# Response to An Bord Pleanala Opinion relating to Transportation & Drainage

# Strategic Housing Development (Reg. Ref ABP-307260-20)

Proposed Residential Development at Fosterstown North SHD, Swords, Co. Dublin

**Document Reference:** 17-062r\_006

PLAN VIEW – PROPOSED LEFT IN LEFT OUT JUNCTION  
SCALE 1:250

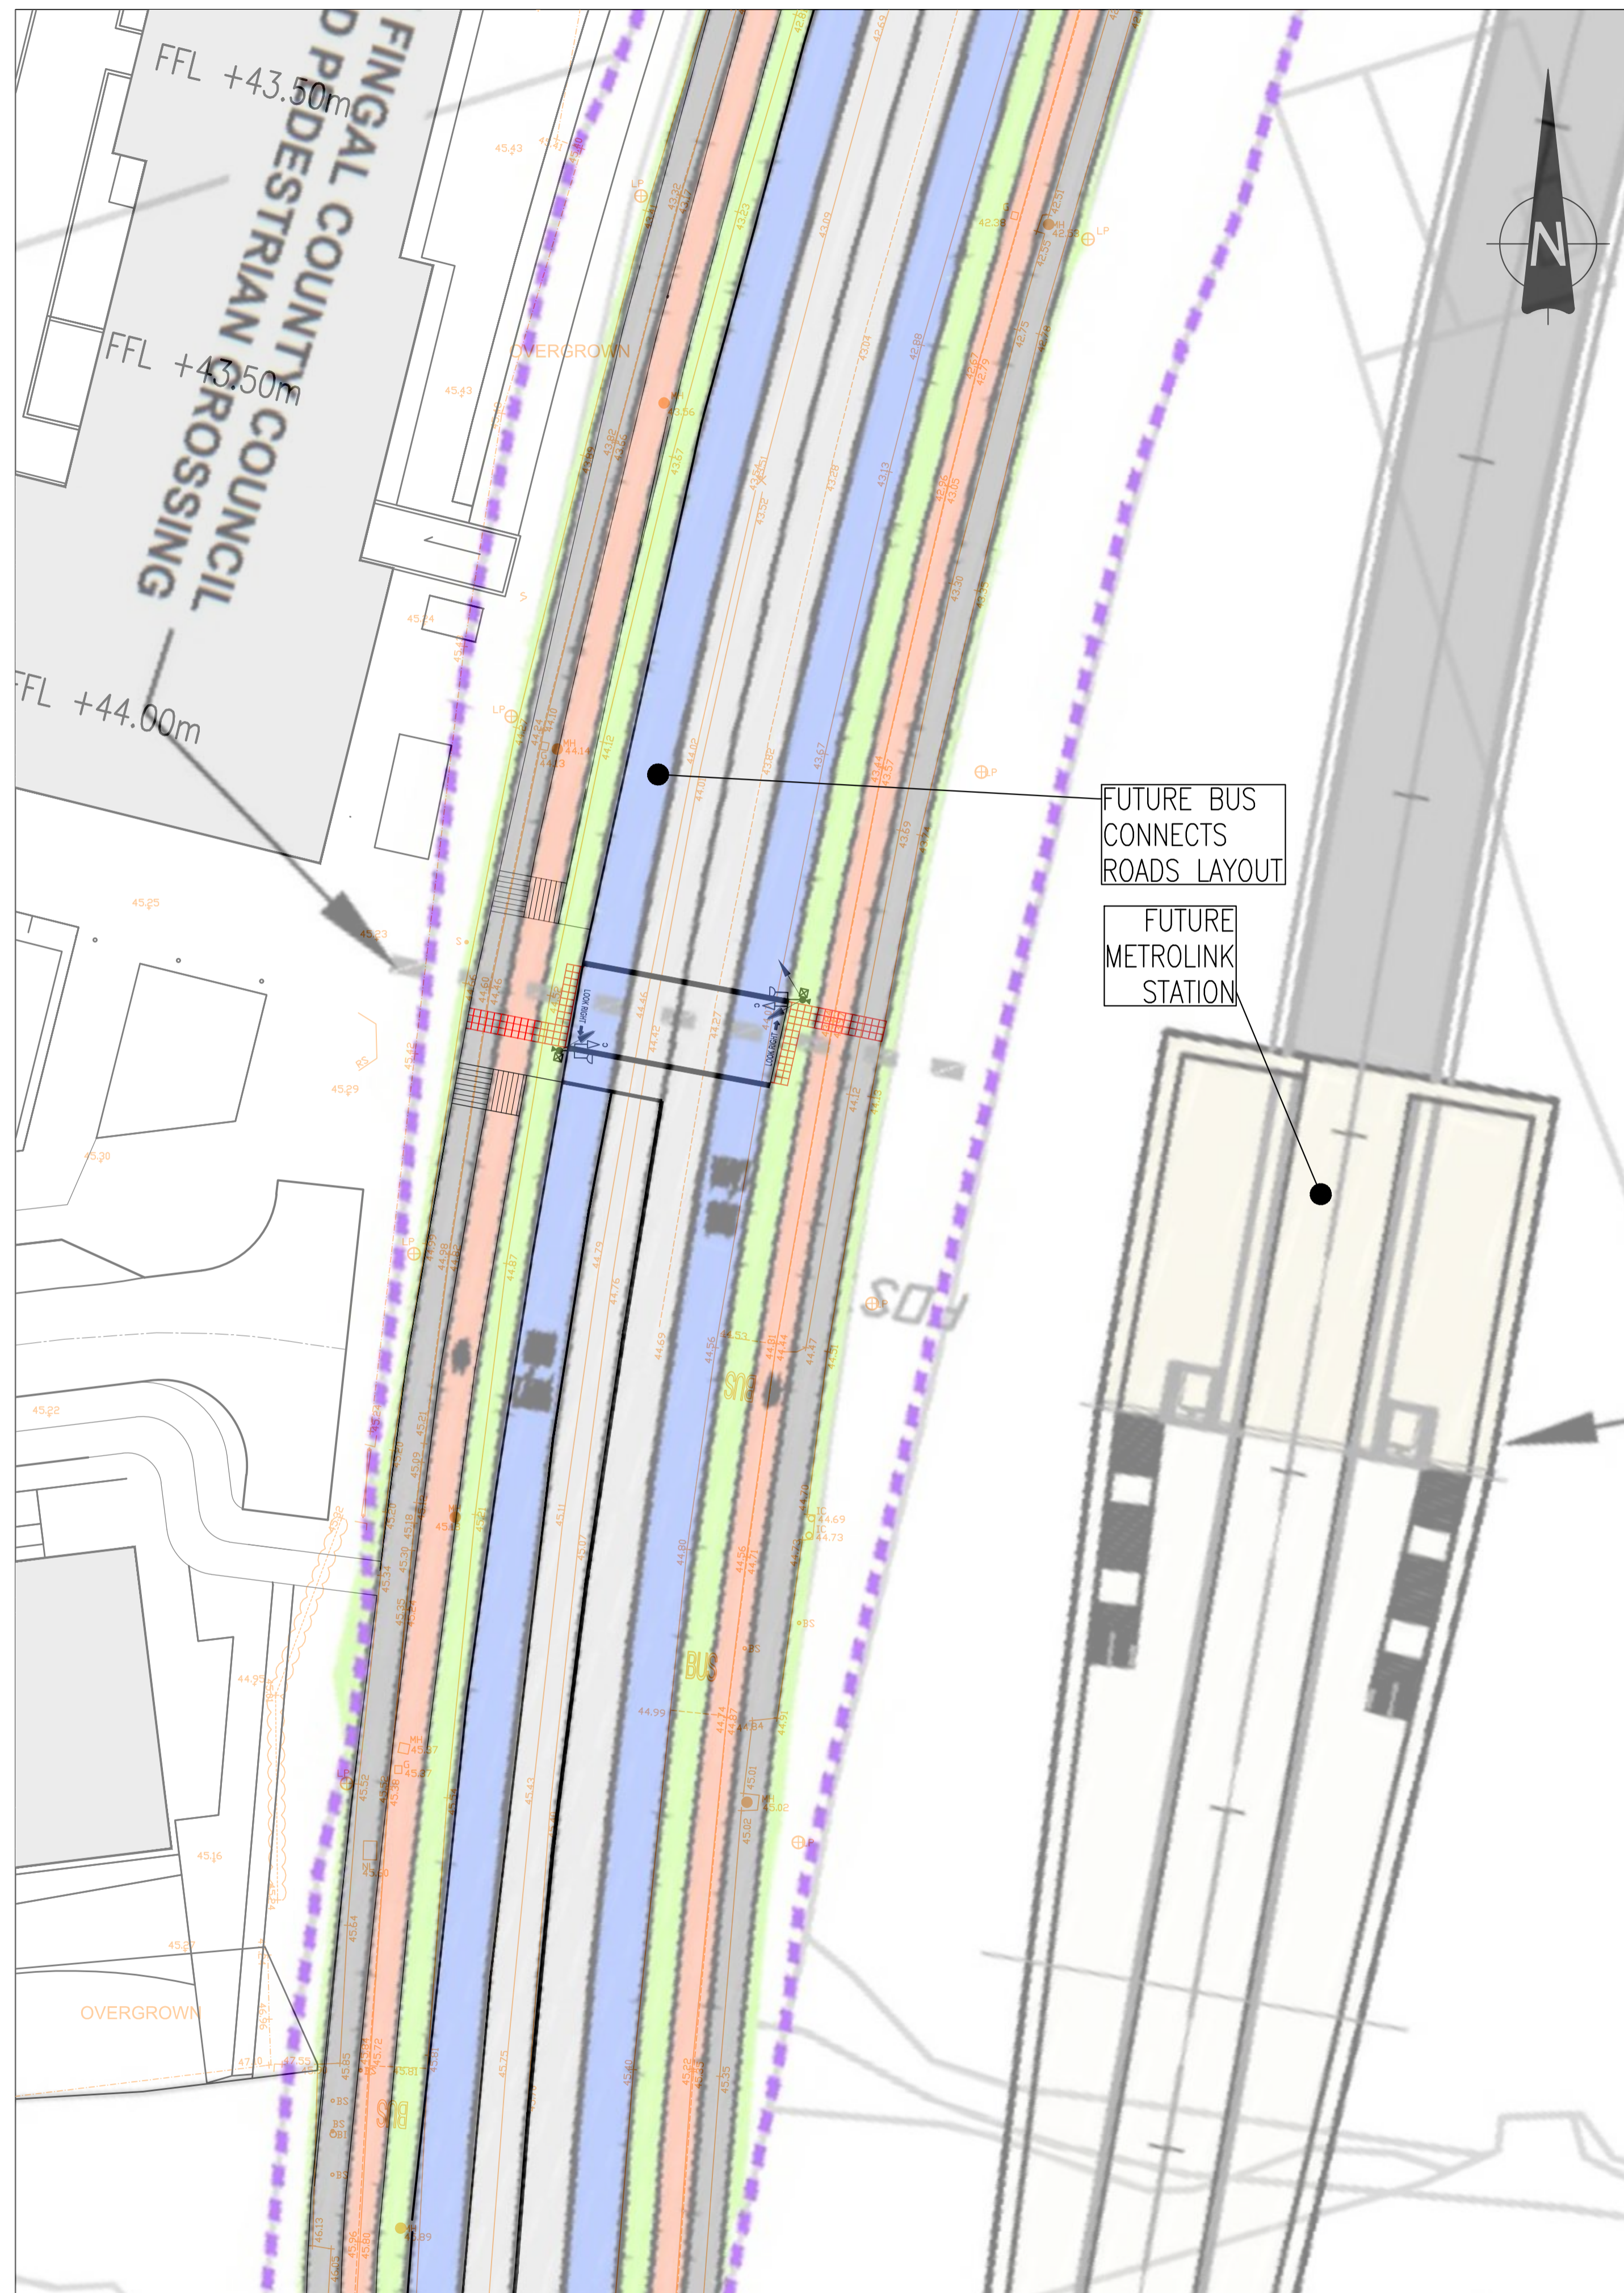
"Further consideration and justification of the documents as they relate to the provision of vehicular access from the proposed development onto the R132 having regard to, inter alia, the policies and objectives of Final County Council as set out in Fosterstown Masterplan 2019 and the implications for the strategic function of the R132 in terms of Bus Connects and Metrolink crossings which are continuing to be advanced. The justification should include, inter alia, alternatives considered/deliverable if applicable Should the proposed entrance off the R132 be maintained at application stage then a full Traffic and Transport Impact Assessment should be submitted indicating, inter alia, impact assessment on existing and possible future; pedestrian infrastructure; cycle infrastructure; bus infrastructure; Metrolink station; and vehicular movement on, and in the vicinity of, the R132. In addition, proposals to provide an interim temporary access from the R132 may wish to be investigated/considered. Any such temporary entrance proposal should include proposals for the closure of the vehicular access and the provision of appropriate public realm works following completion of the Fosterstown Link Road and associated road infrastructure to service the site via the lands to the north as identified in the Fosterstown Masterplan (May 2019). It is advisable that any entrance proposal off the R132 be subject of detailed design consultation with Fingal County Council in conjunction with the NTA and TII."

In order to facilitate a left in/left out it is only necessary to provide a break in the bus lane and to install plastic bollards (to prevent right turning) along the existing central reservation. Details are presented on our enclosed drawing No. 17-062/P120.

Internally, the scheme has been designed so that the access can be closed off in the future when the vehicular access to the lands is made available from the lands to the north and a turning head can be installed as the internal road will become a cul-de-sac once the junction is closed off.

Details of the proposed cul-de-sac with turning head are presented on our enclosed drawing no. 17-062/P121.

**FOUL CONNECTION PROPOSED BY IRISH WATER – EXTRACT FROM IRISH WATER CONFIRMATION OF FEASIBILITY**  
N.T.S

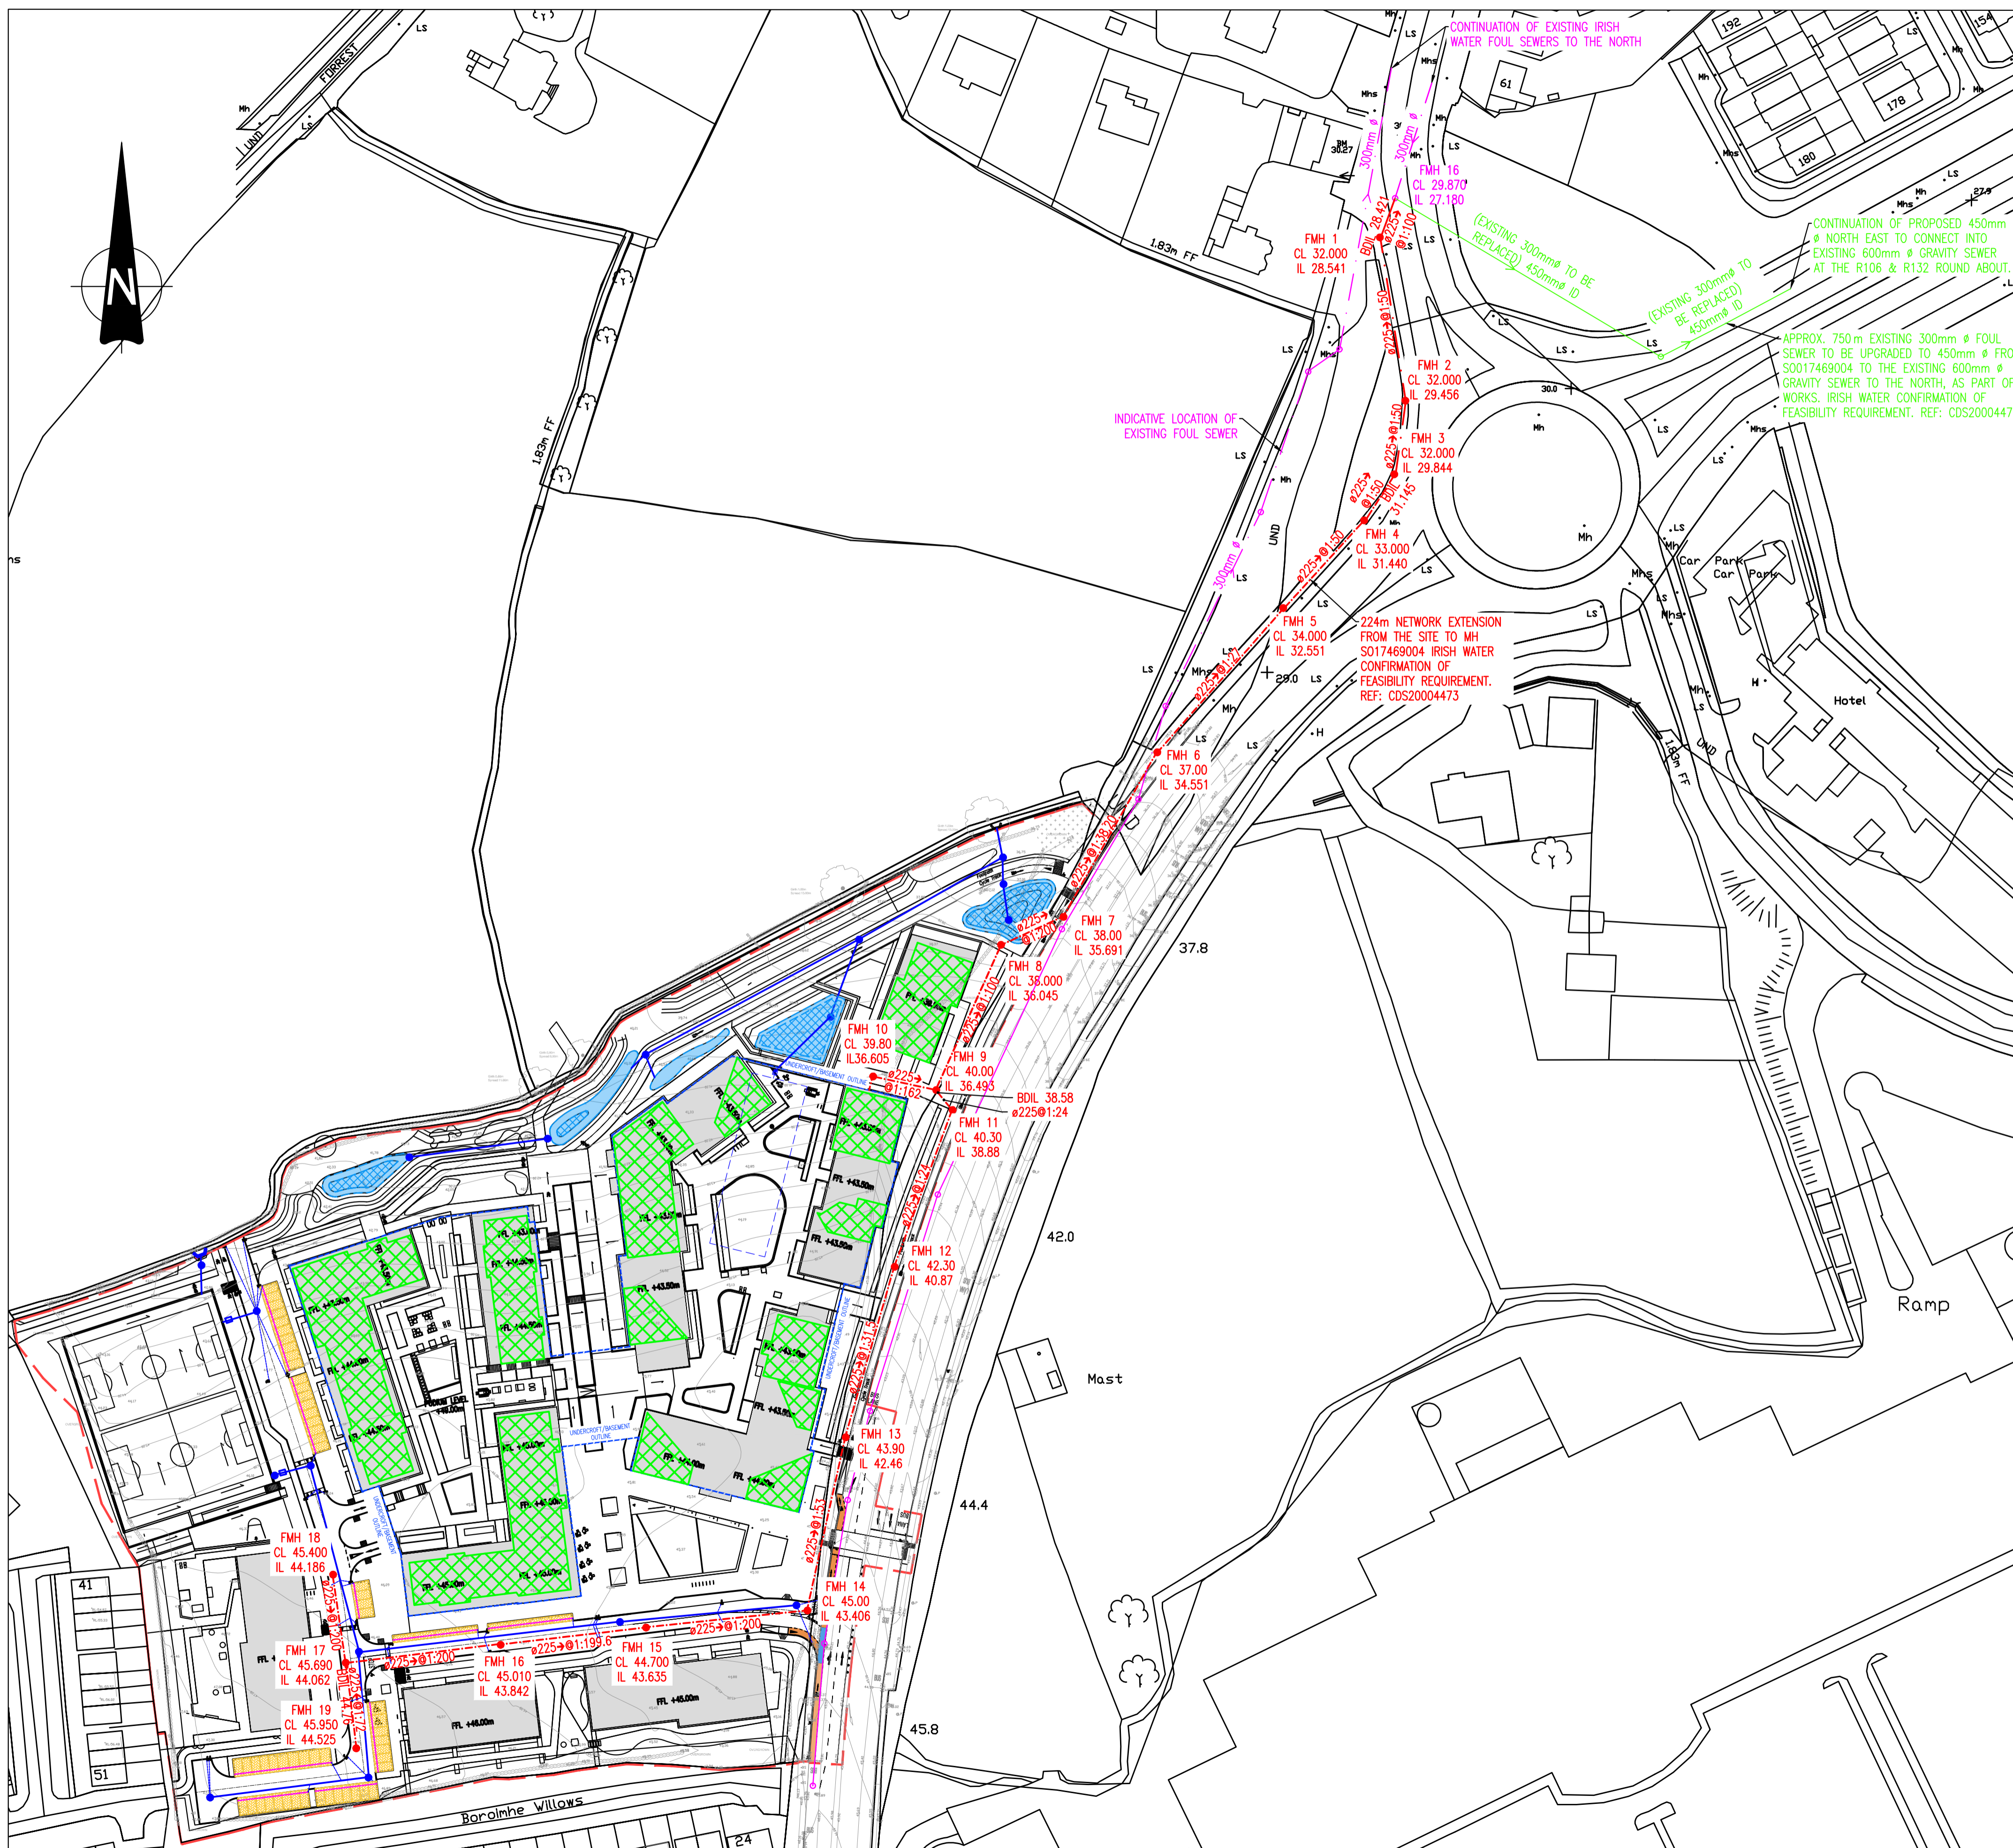
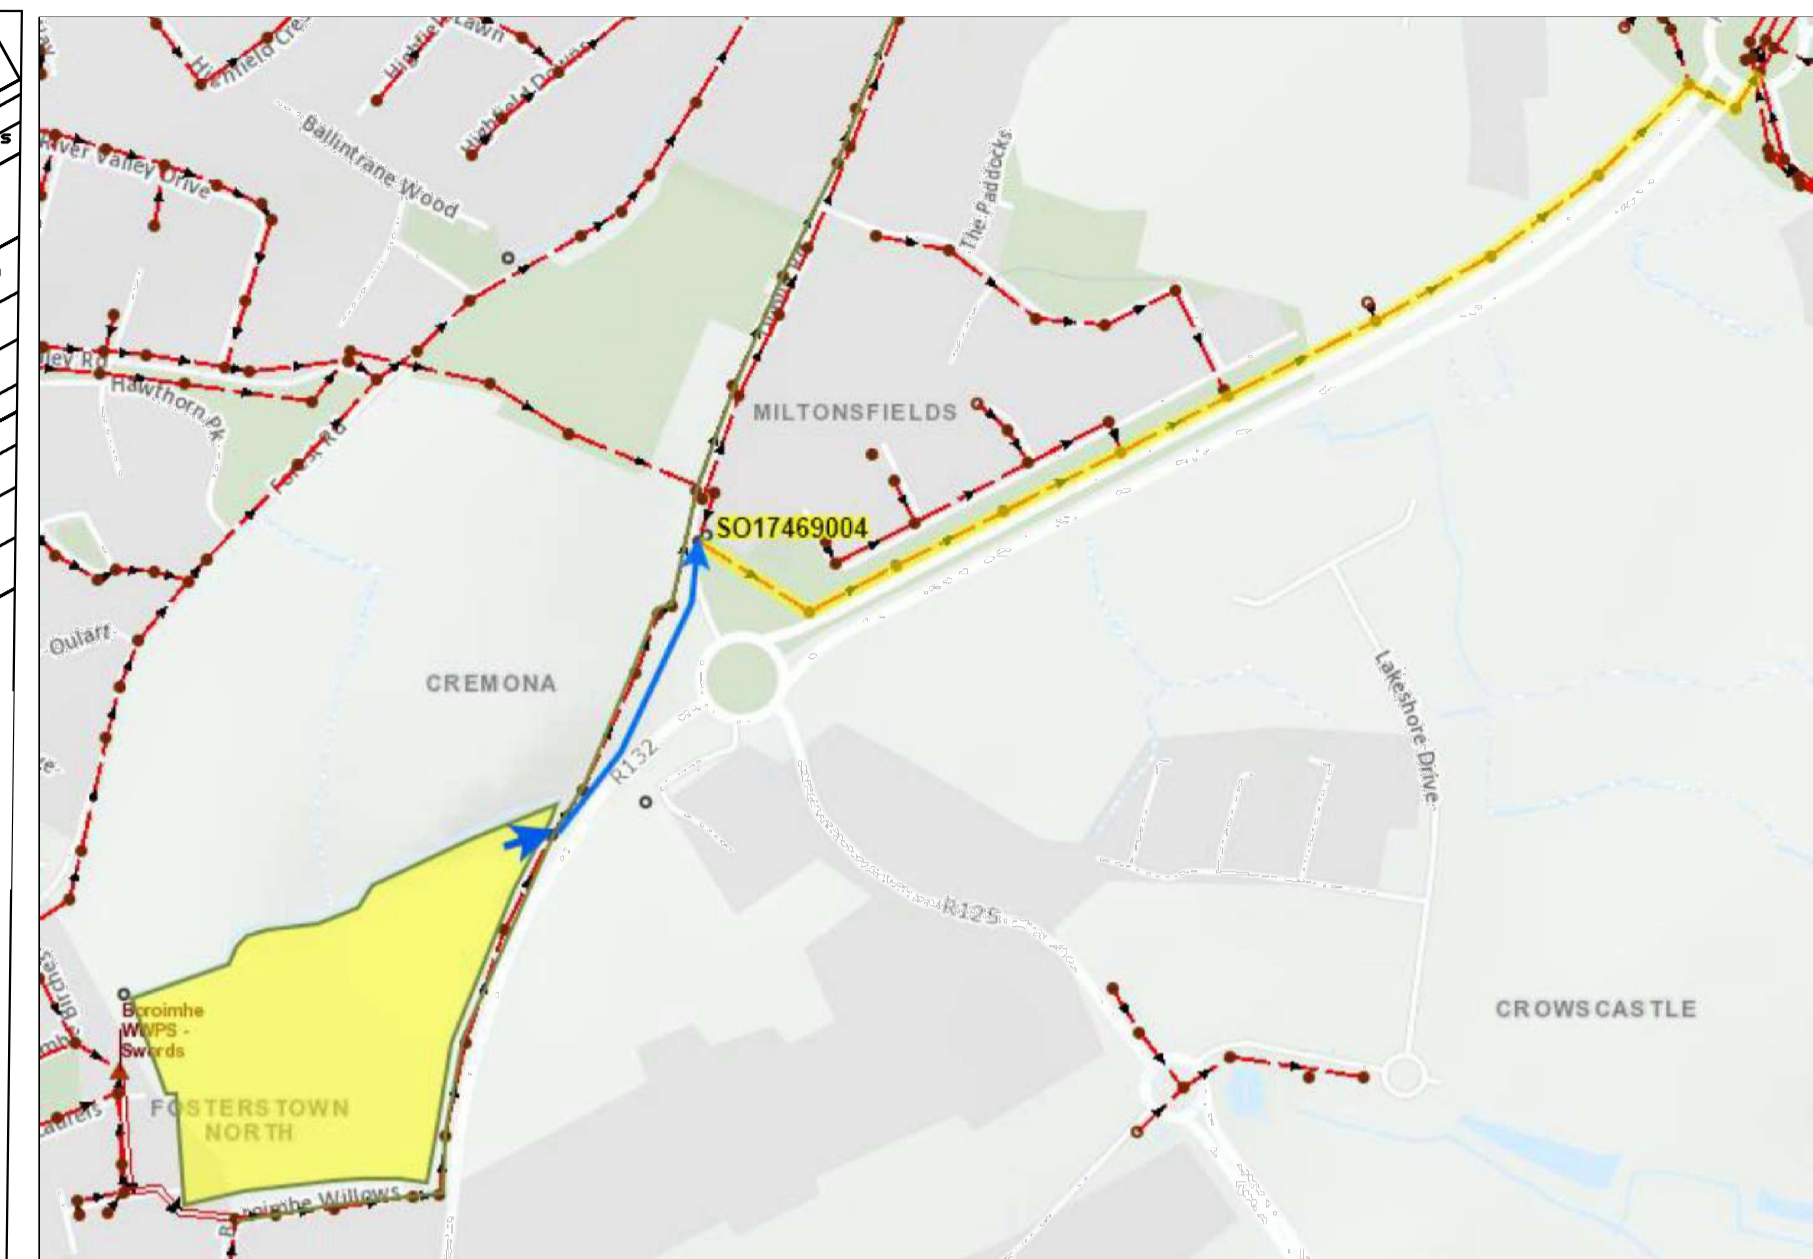
"Further consideration of the documents as they relate to foul water drainage proposals to service the development. The documents should provide details of necessary upgrade works required to facilitate the development to include, inter alia: Plans and particulars, having regard to the significant wastewater network constraints raised by Irish Water in their report dated 3<sup>rd</sup> July 2020.

Clarity to be provided concerning who is to deliver the works; the status of any planning and other consents required to deliver the infrastructure; the timelines involved in the delivery of the required infrastructure in the context of the proposed strategic housing development.

We have now obtained more precise details of the required upgrades from Irish Water. In this regard see Figure 11 below which is an extract from the most recent Confirmation of Feasibility received on 17 February 2021:-

The connection to the public sewer together with the upgrade of the existing pipework will be carried out by Irish Water under the Connection Agreement that will be entered into with Irish Water. In this regard the normal procedure is that works within the public roadways in respect of Irish Water infrastructure (proposed or existing) will be undertaken by Irish Water. The costs for the upgrade works or extension of the public sewers is calculated by Irish Water when the Connection Application is submitted to Irish Water and these costs are then added onto the Irish Water "Standard Charges" by Irish Water in the Connection offer. They would appear in the Connection Offer as "Quotable Charges".

Planning permission is not required for Irish Water to carry out these upgrade works, which are all contained within public roads/verges.

In conclusion, Irish Water have confirmed that a foul water connection to serve the proposed development is feasible subject to upgrade works. The upgrade works will be carried out by Irish Water and will be paid for by the applicant. The upgrade works can be delivered in a timely manner as they do
